Rezoning Petition Review

Date of Review: December 17, 2007 (**Revised January 15, 2008**)

Rezoning Petition #: 08-33

Location of Property: Approximately 2.08 acres located on the west side of Park Road between Heather Lane and Drexel Place

**PRELIMINARY
SITE PLAN**

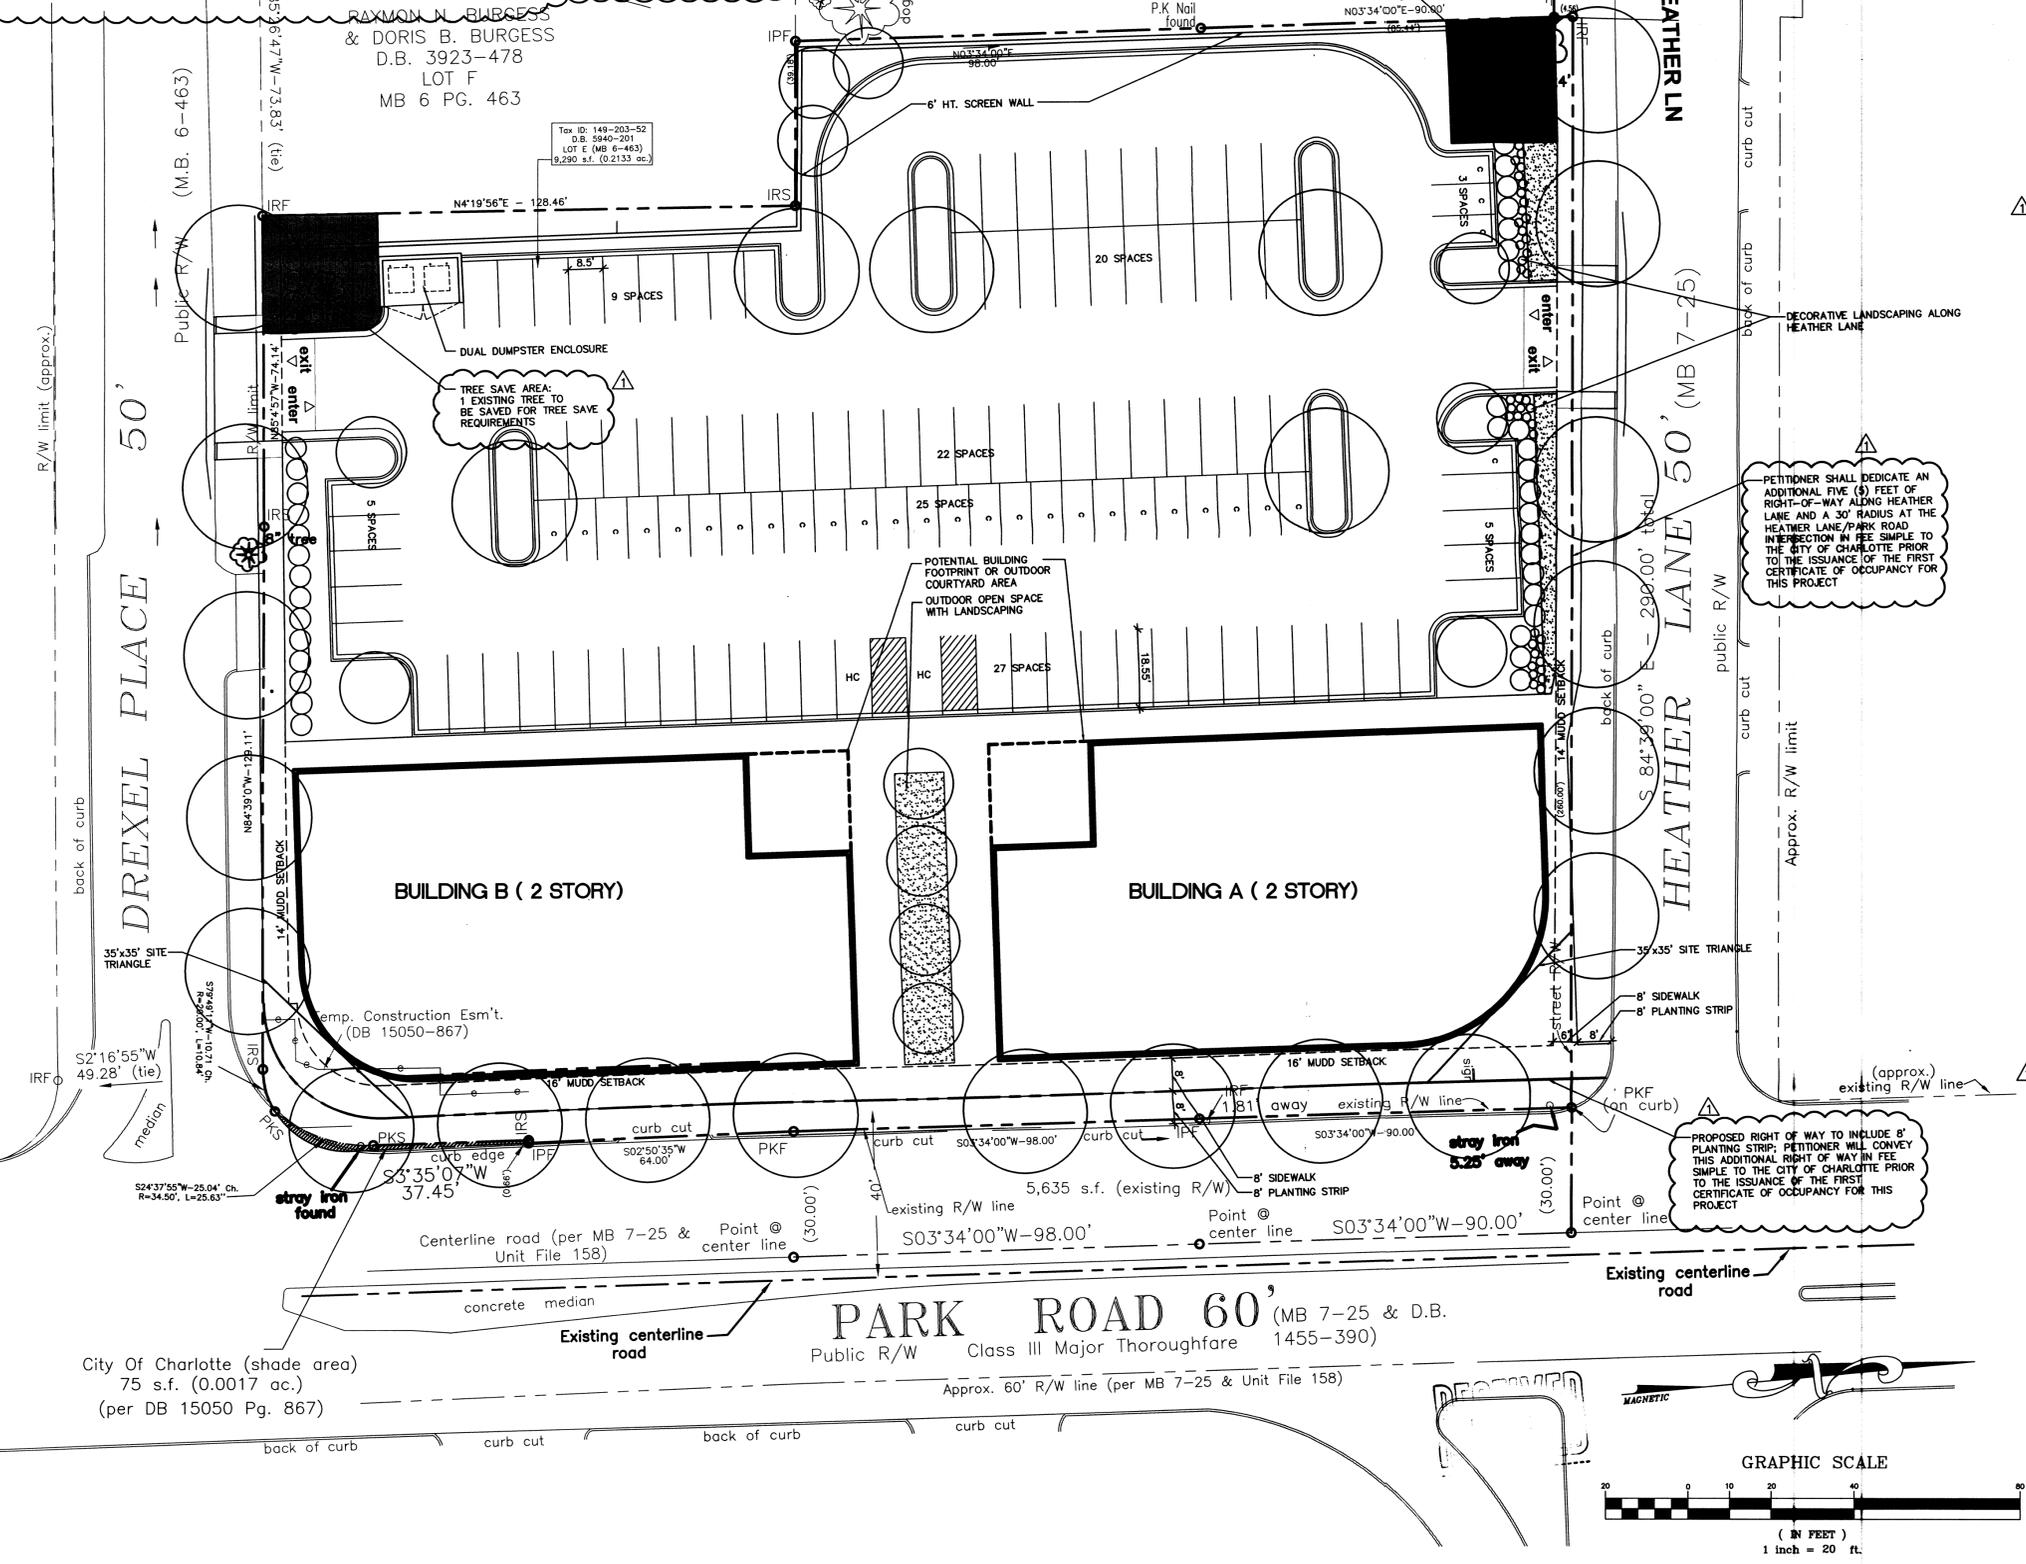
Recommendations
Concerning Storm Water: **Remove Note 14 concerning Stormwater Detention and add the following note on the petition.**

The petitioner acknowledges that other standard development requirements imposed by other city ordinances, standards, policies, and appropriate design manuals will exist. Those criteria, (for example those that regulate streets, sidewalks, trees, storm water, post construction controls, and site development, etc.) will apply to the development site. Conditions set forth in this petition are supplemental requirements imposed on the development in addition to other standards. Where conditions on this plan differ from ordinances, standards, policies, and approaches in existence at the time of formal engineering plan review submission the stricter condition or existing requirements shall apply.
